ENG-PPR19009-R3-CDs.pdf Markup Summary

Engineering Review
09/10/2019 12:55:32 PM
dsdrice
JsdRice@colorado.gov
(719) 526-7877
EPC Planning & Community
Development Department

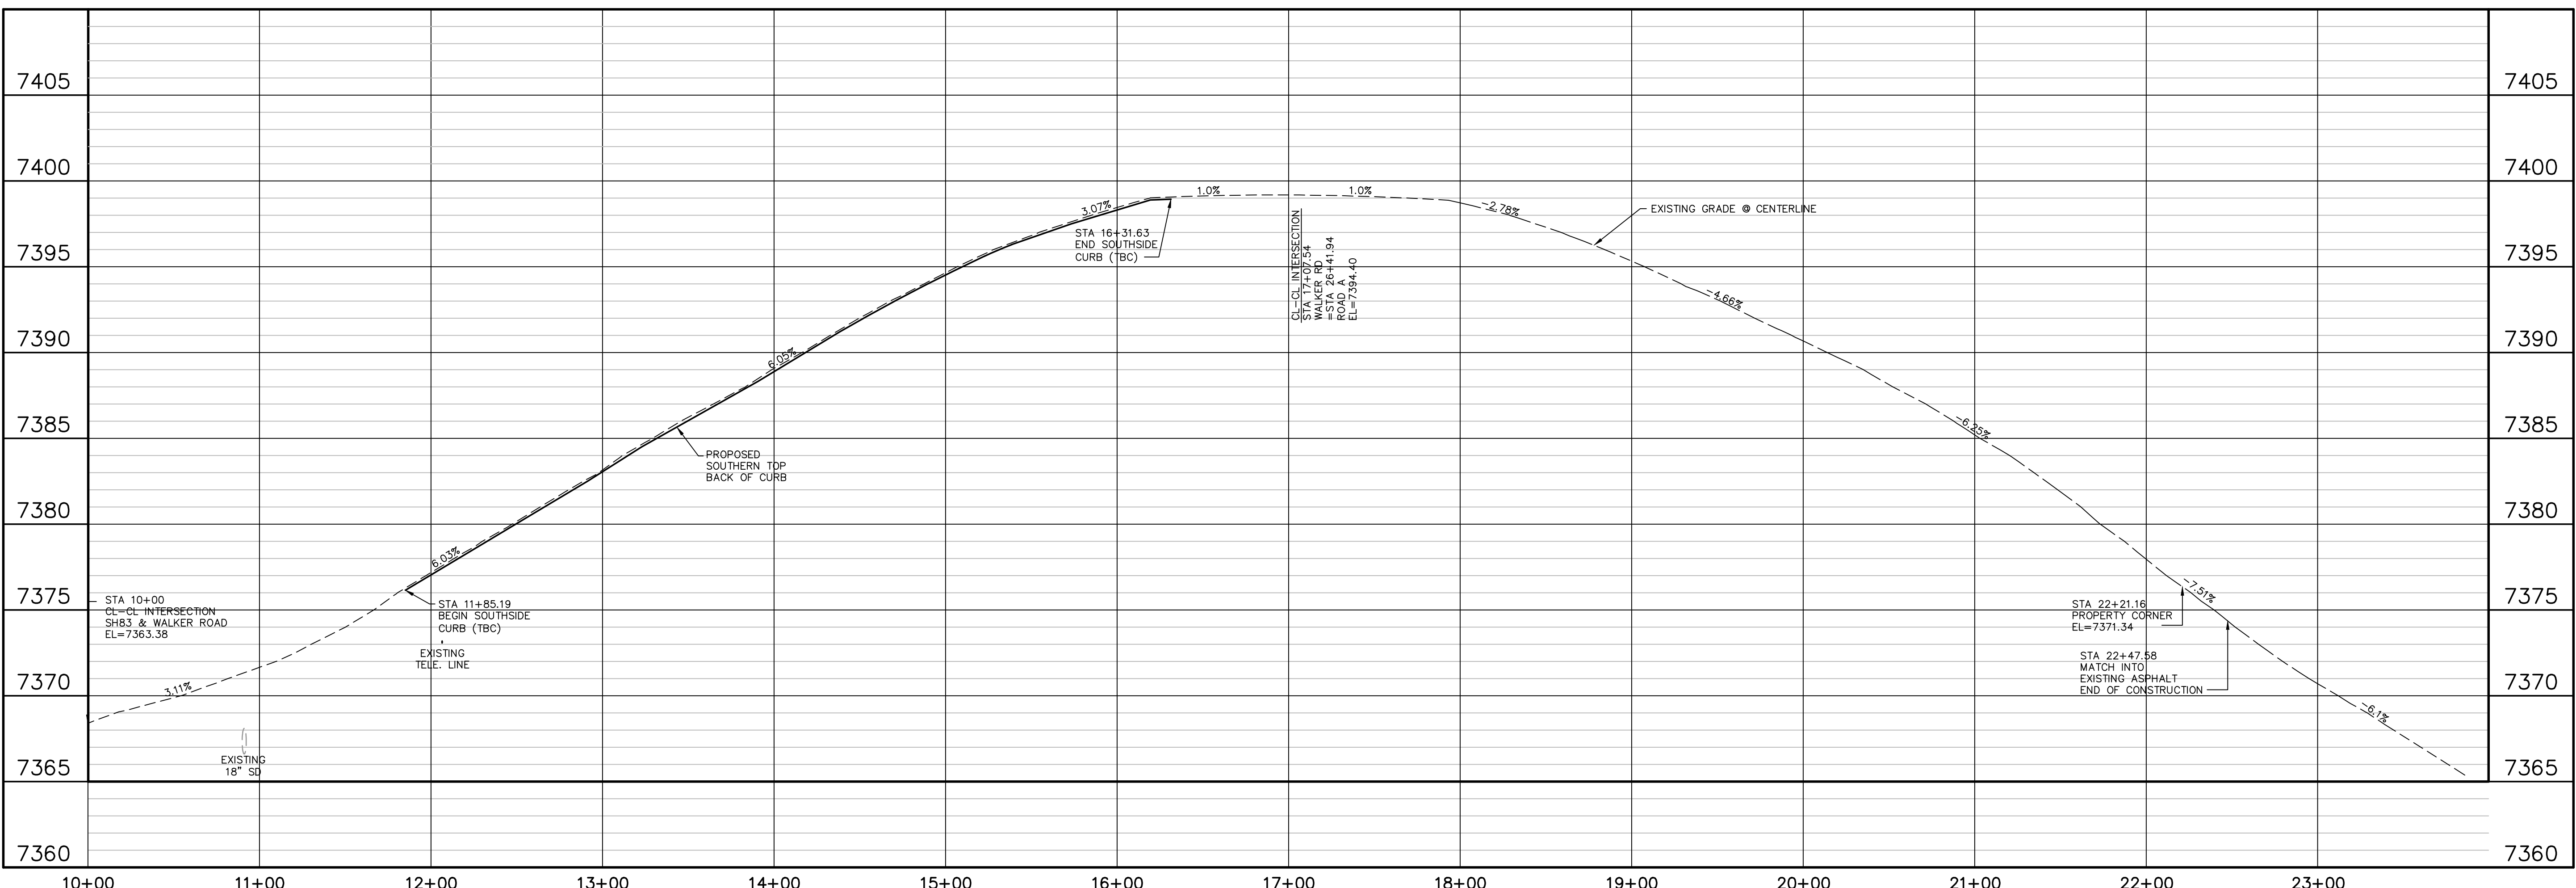
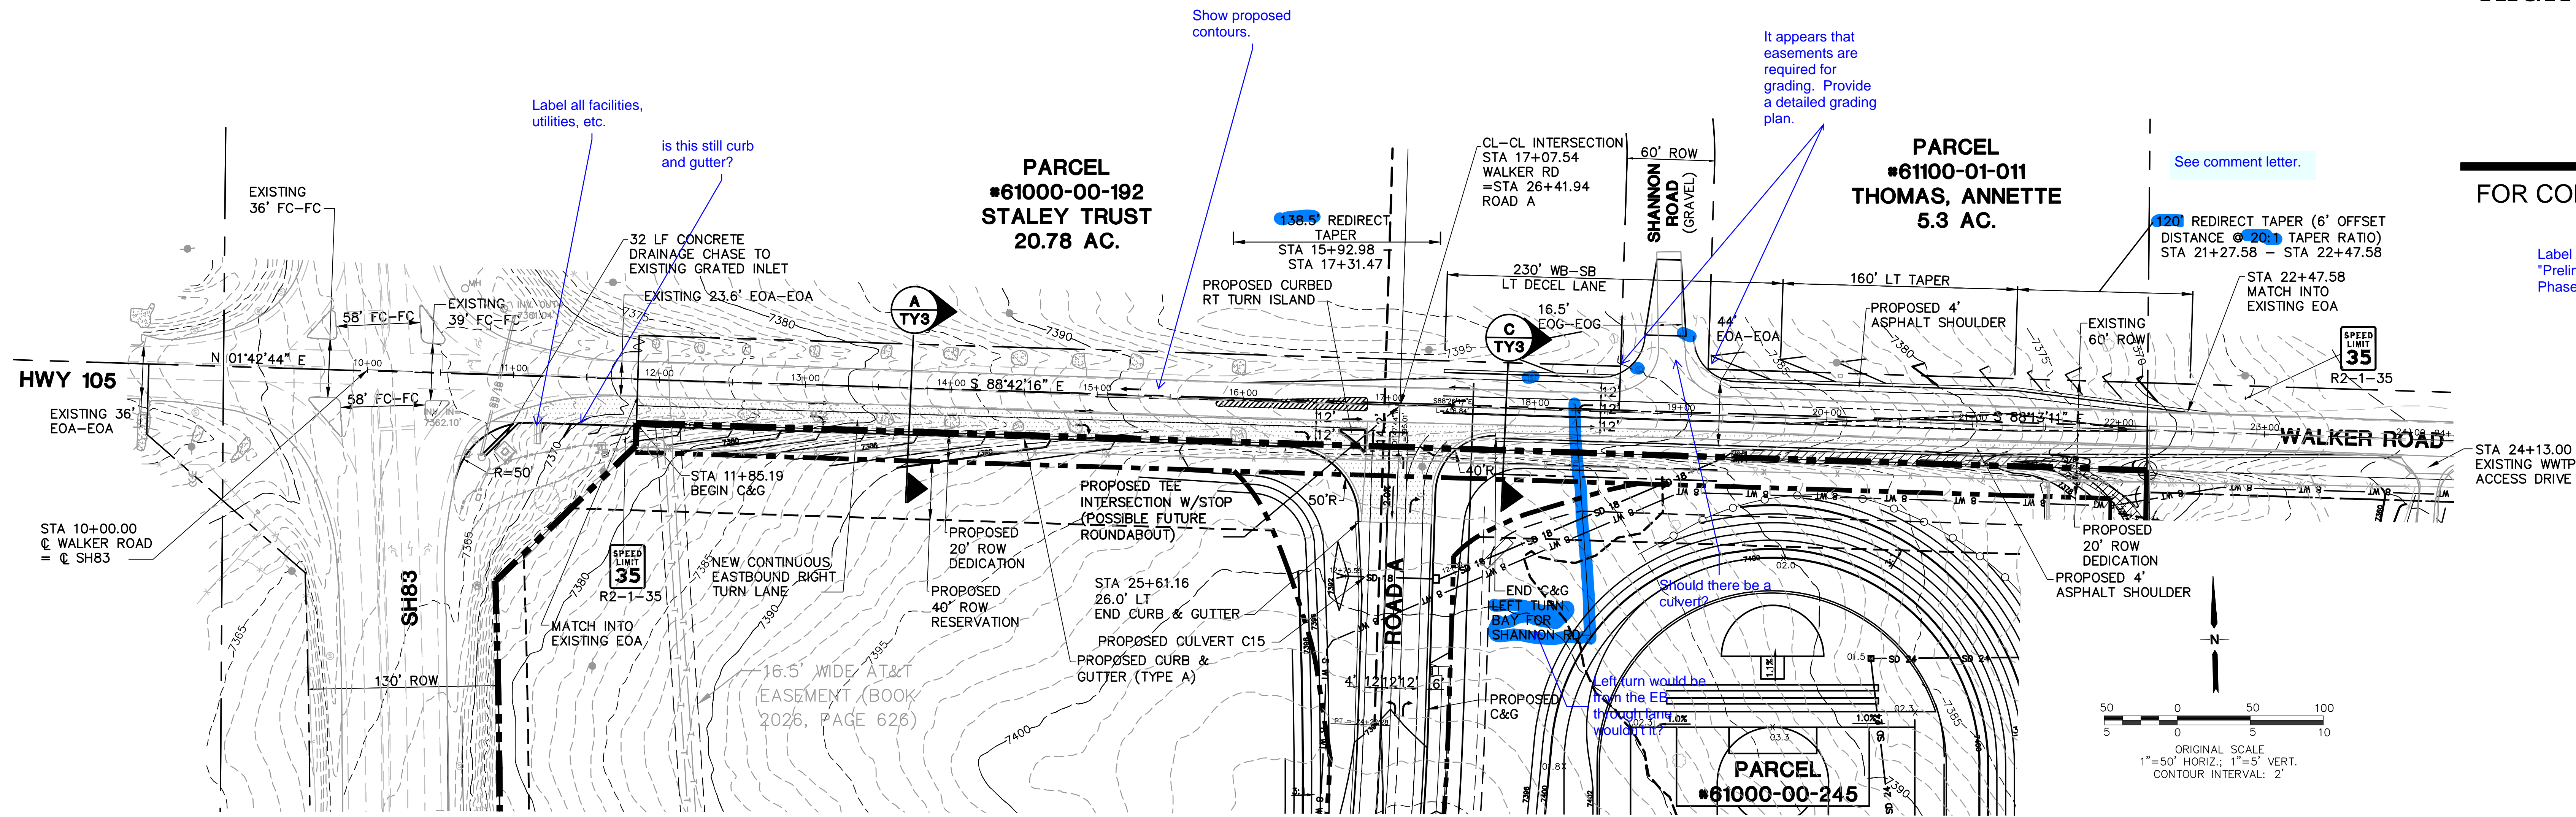
It appears that easements are required for grading. Provide a detailed grading plan.

Show proposed contours.

Label as
"Preliminary" for
Phase 1b

Should there be a culvert?

Provide a legend

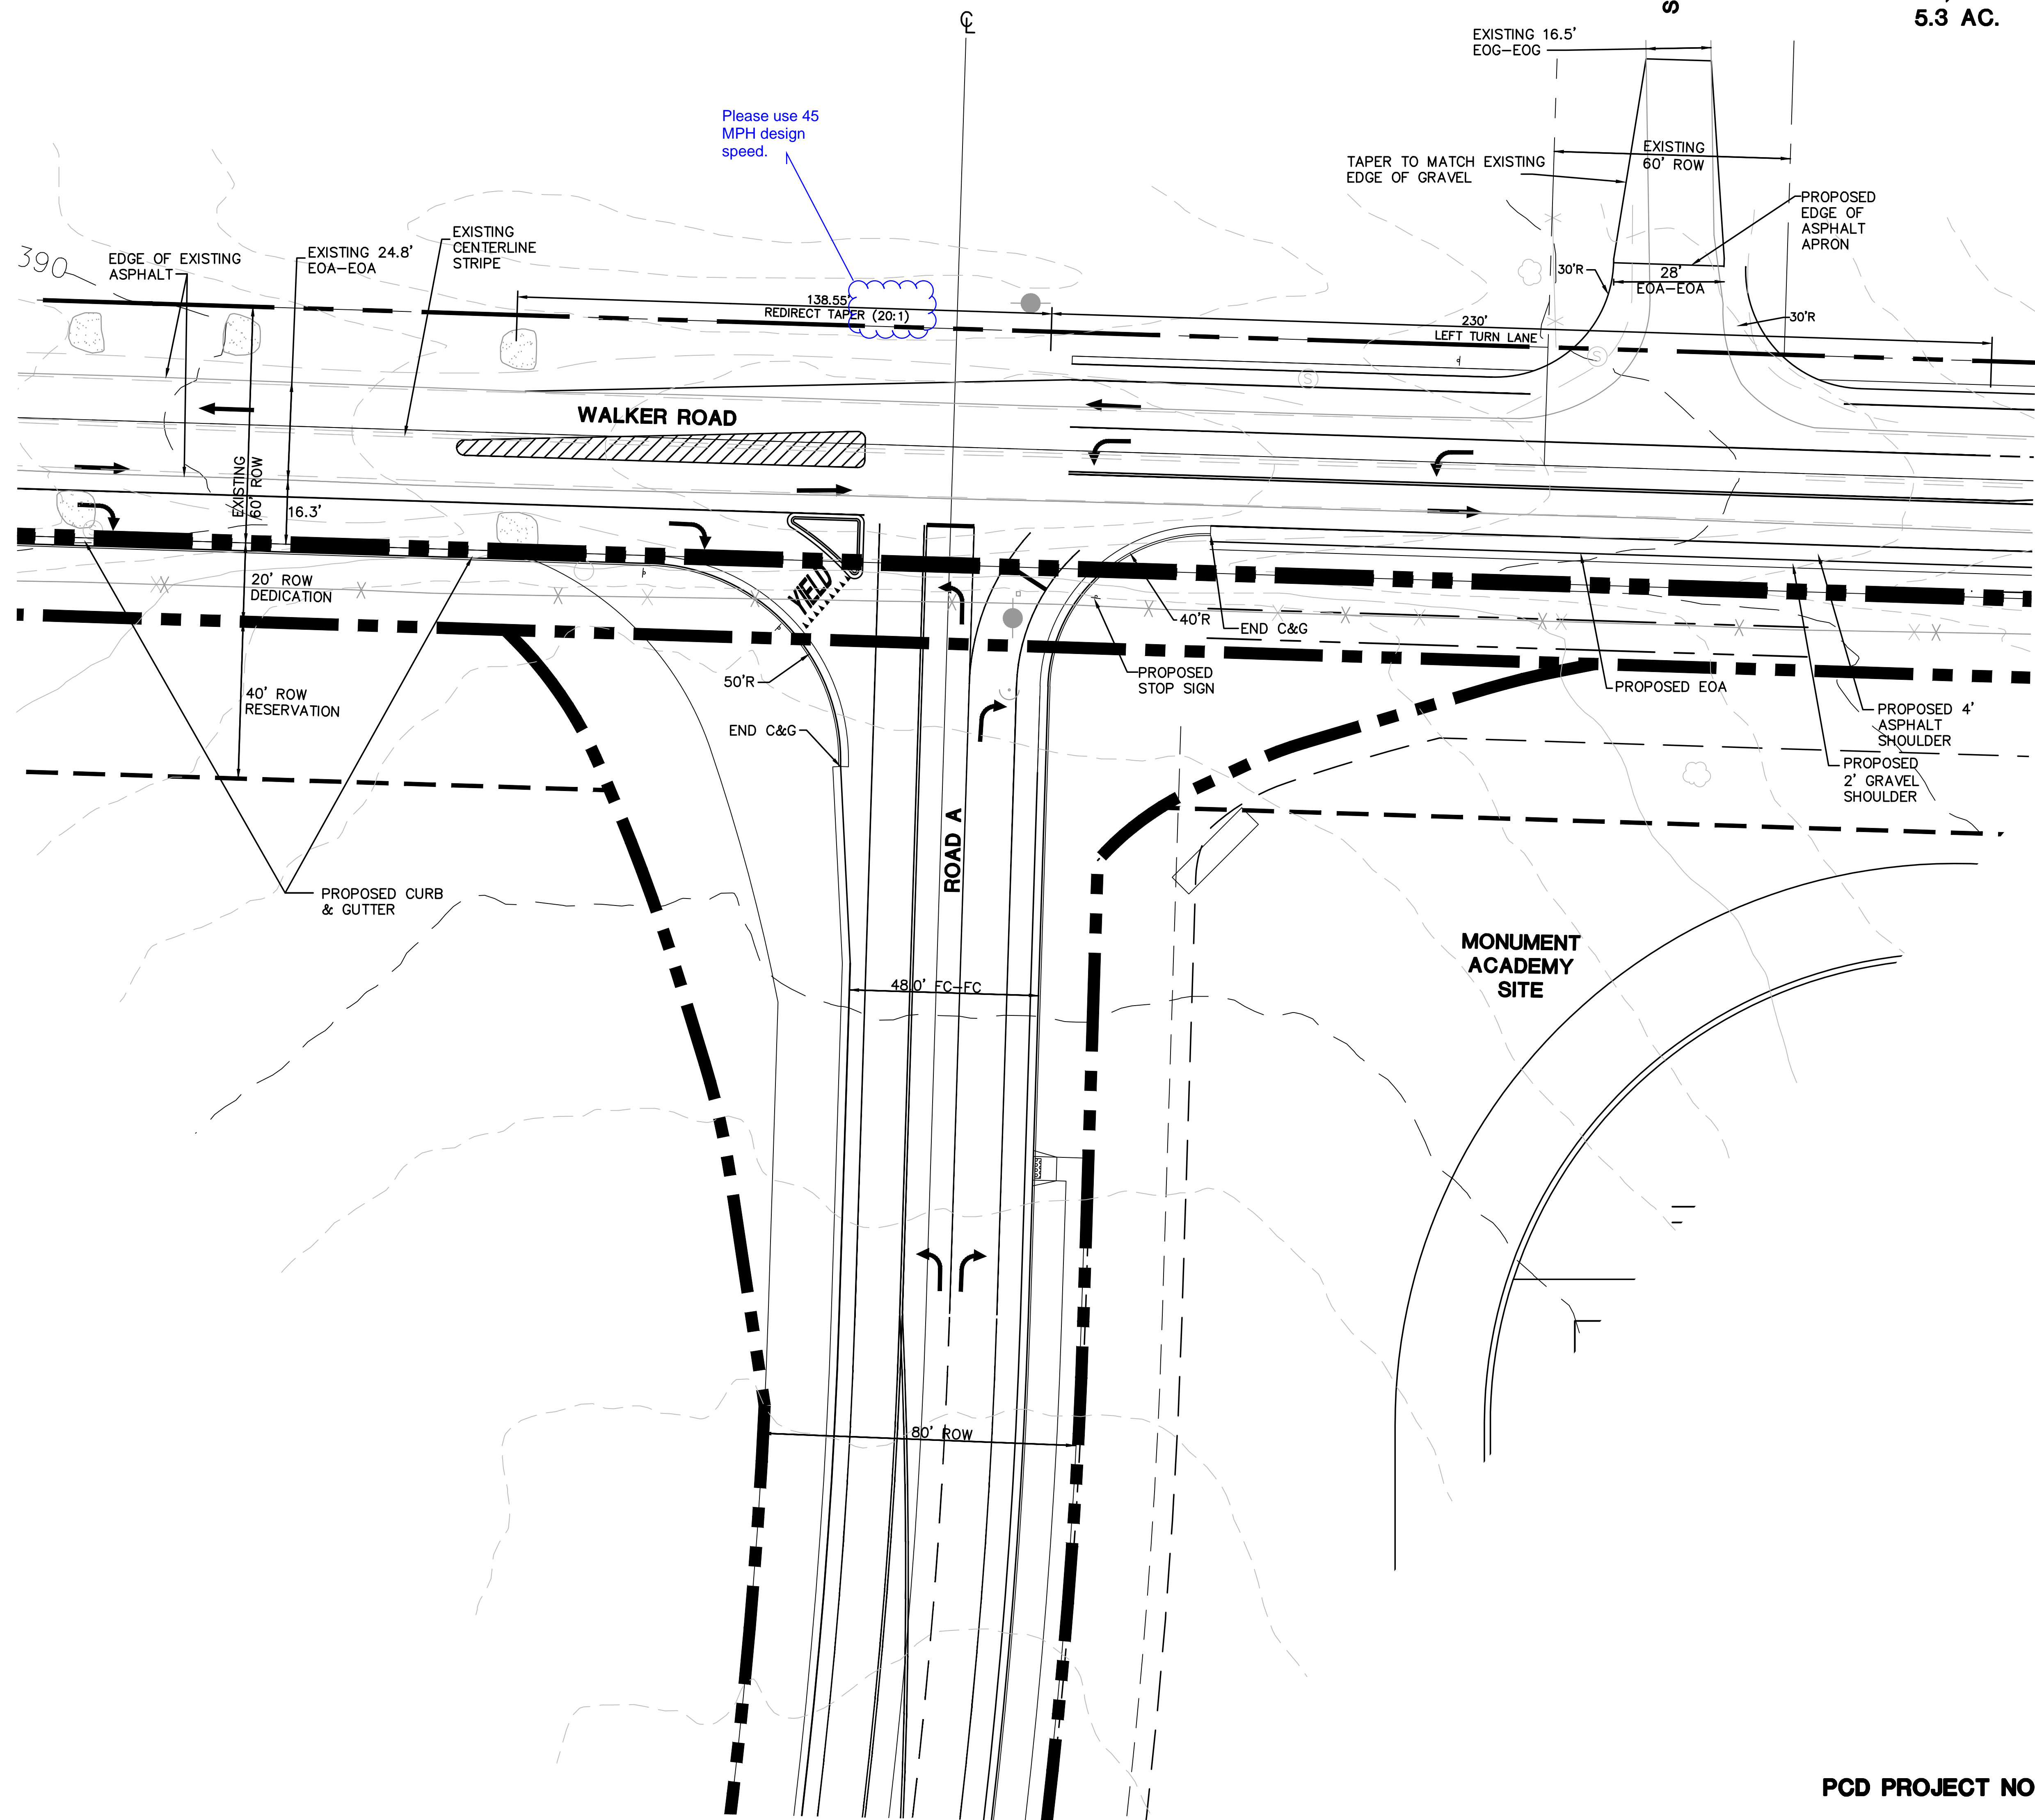
Please use 45 MPH design speed.
